**Client:** S.W. Cole Engineering, Inc.**Project:** 169 Newbury Street**SWCE Project #:** 16-0910**Date:** November 21, 2016**Subject:** Site Inspection of Structural Steel**Report:** 002

1 BRACE A
3/16" = 1'-0"

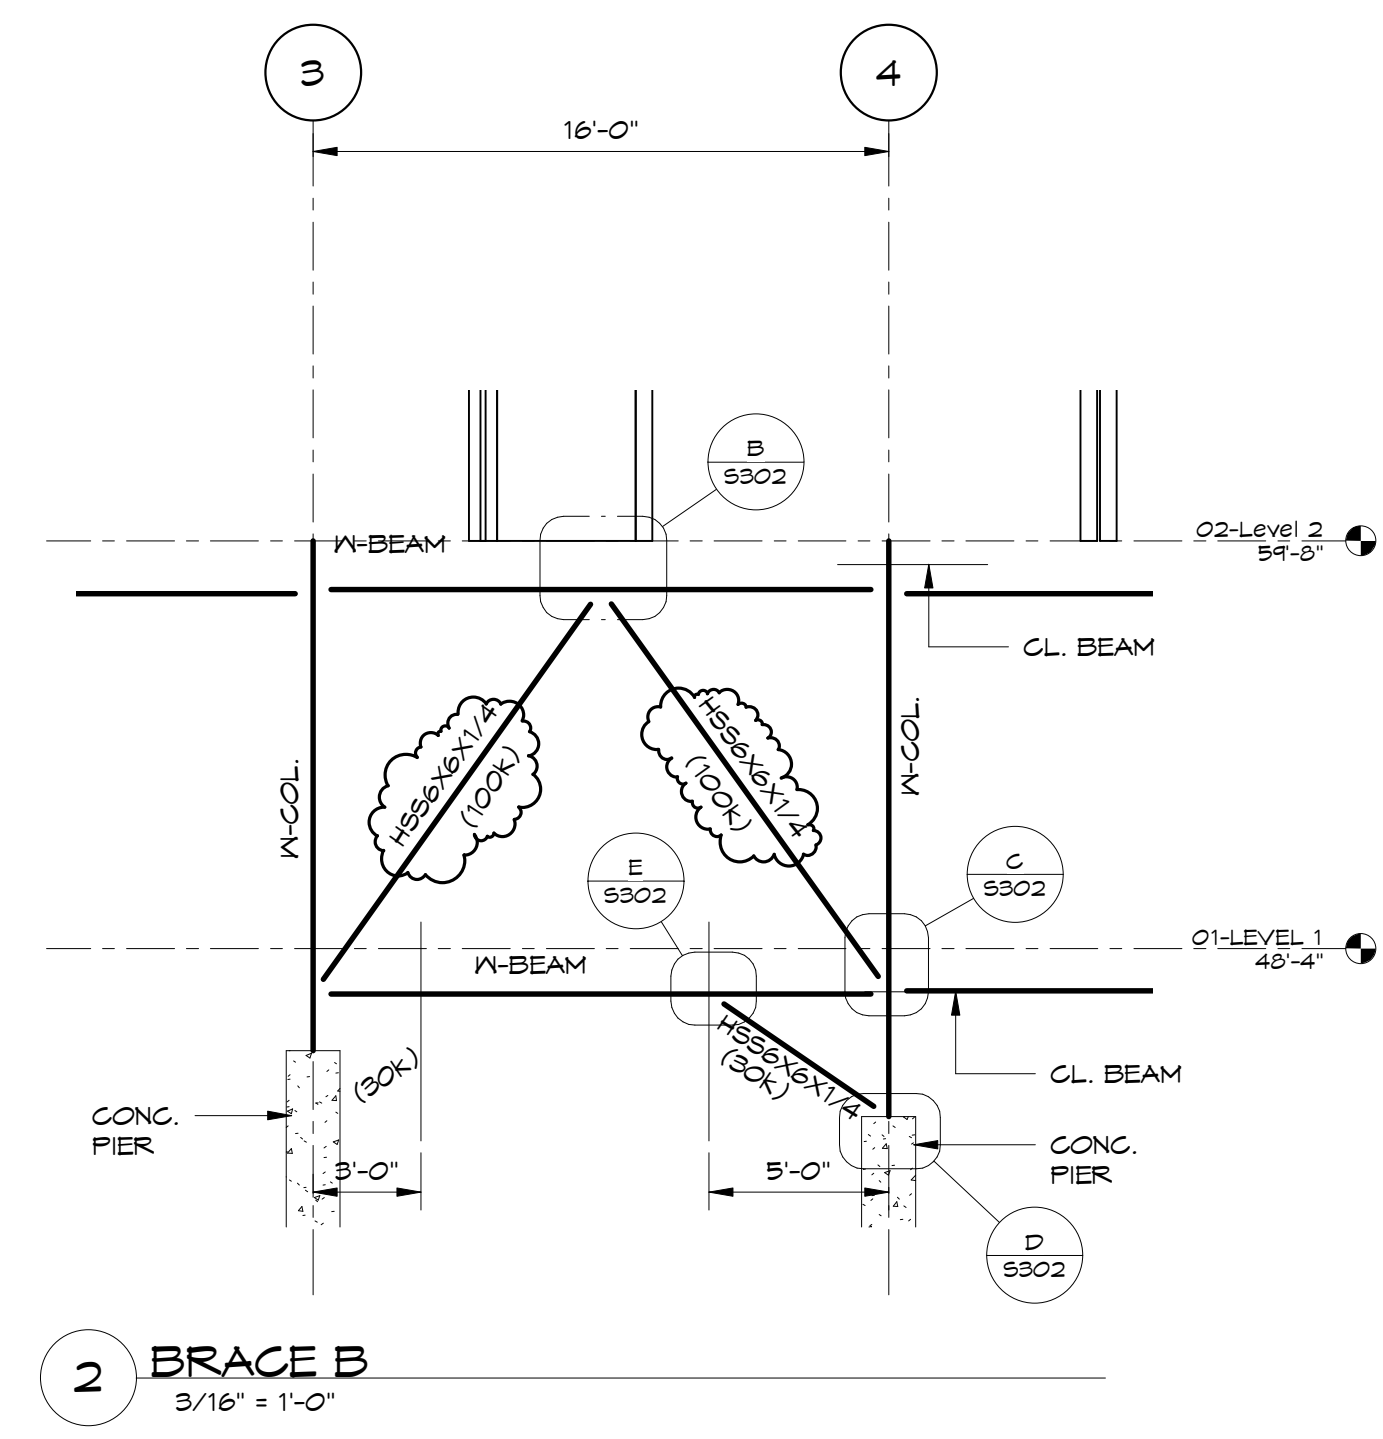
1. Welds were found to be missing on Brace A at the upper end of one member between lines 4 and 5.
